DECISION DELEGATED TO DEVELOPMENT MANAGER

Application No: H08-0792-19 **Applicant:** Mr & Mrs Taylor
Proposal: Proposed rear extension, loft conversion and internal alterations
Location: 33 Low Gate Gosberton Spalding
Terminal Date: 7th October 2019

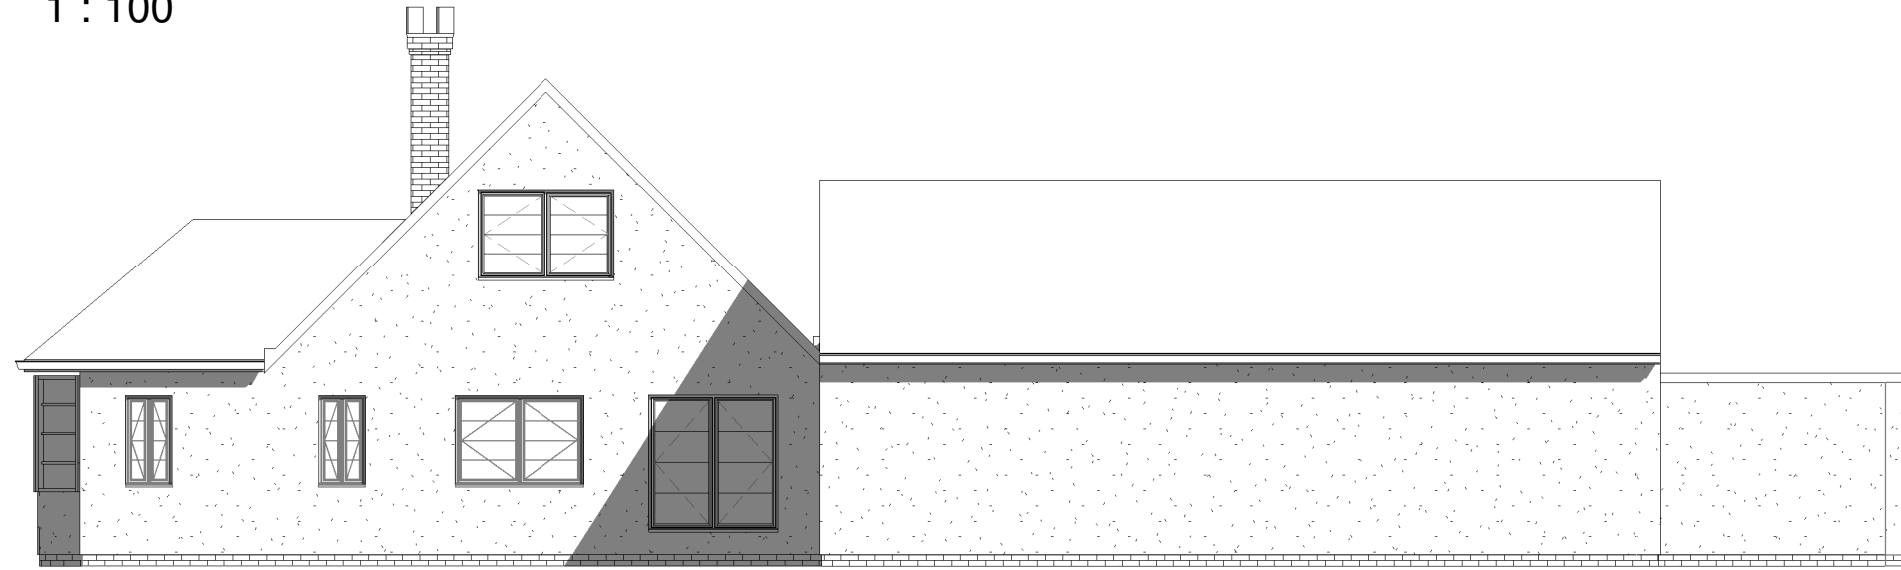
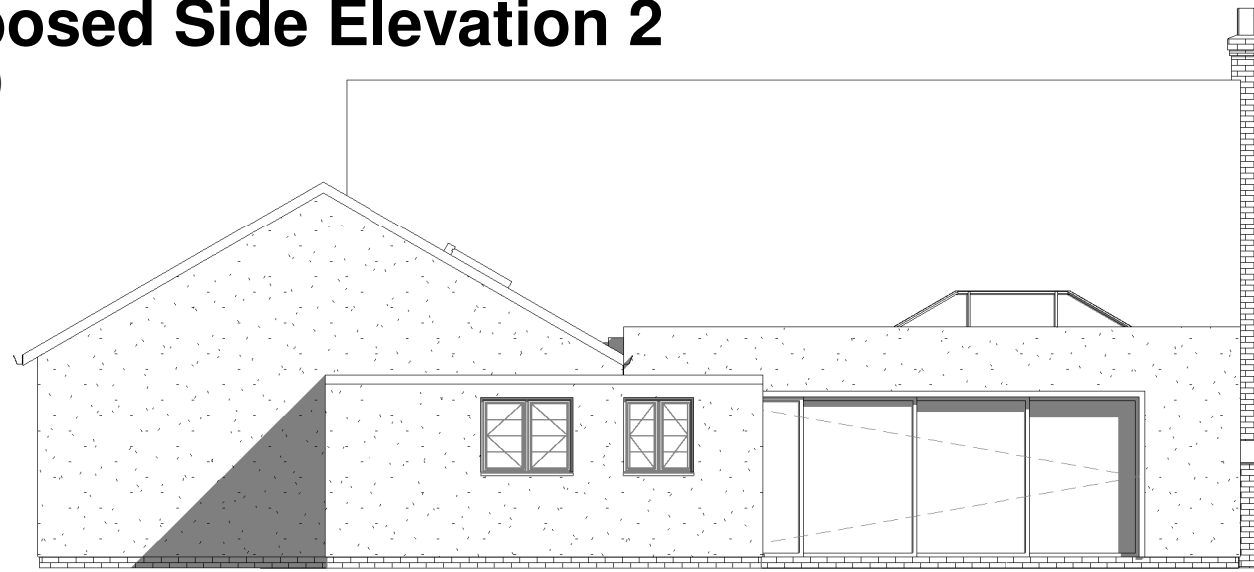
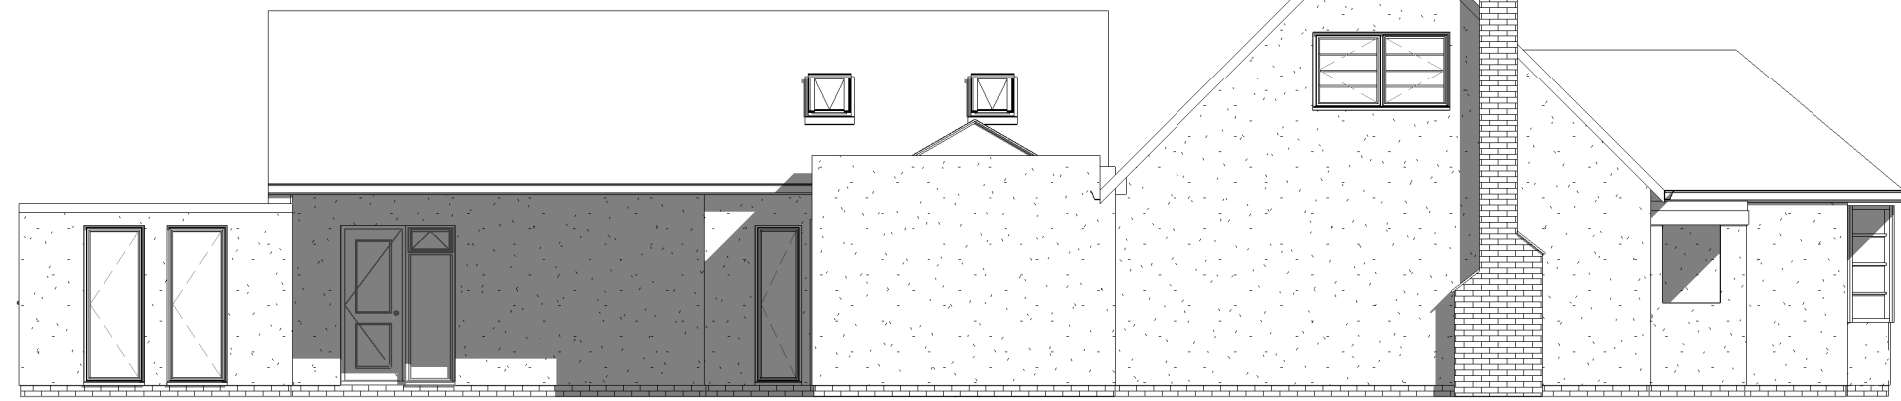
A white "k-rend" render finish is proposed on the entire property and the proposed windows will be a white uPVC which will match the existing. Given that existing dwellings in the vicinity are varied in terms of design and materials (brick and render), this is considered acceptable.

The proposed plans show that there will be new windows at the first floor for the loft conversion, which would be facing east and west from the property. However, the windows on the facing elevation of no. 35 to the west are obscure glazed and the new window on the eastern facing elevation would be obscure glazed. There should therefore not be a material adverse impact on privacy.
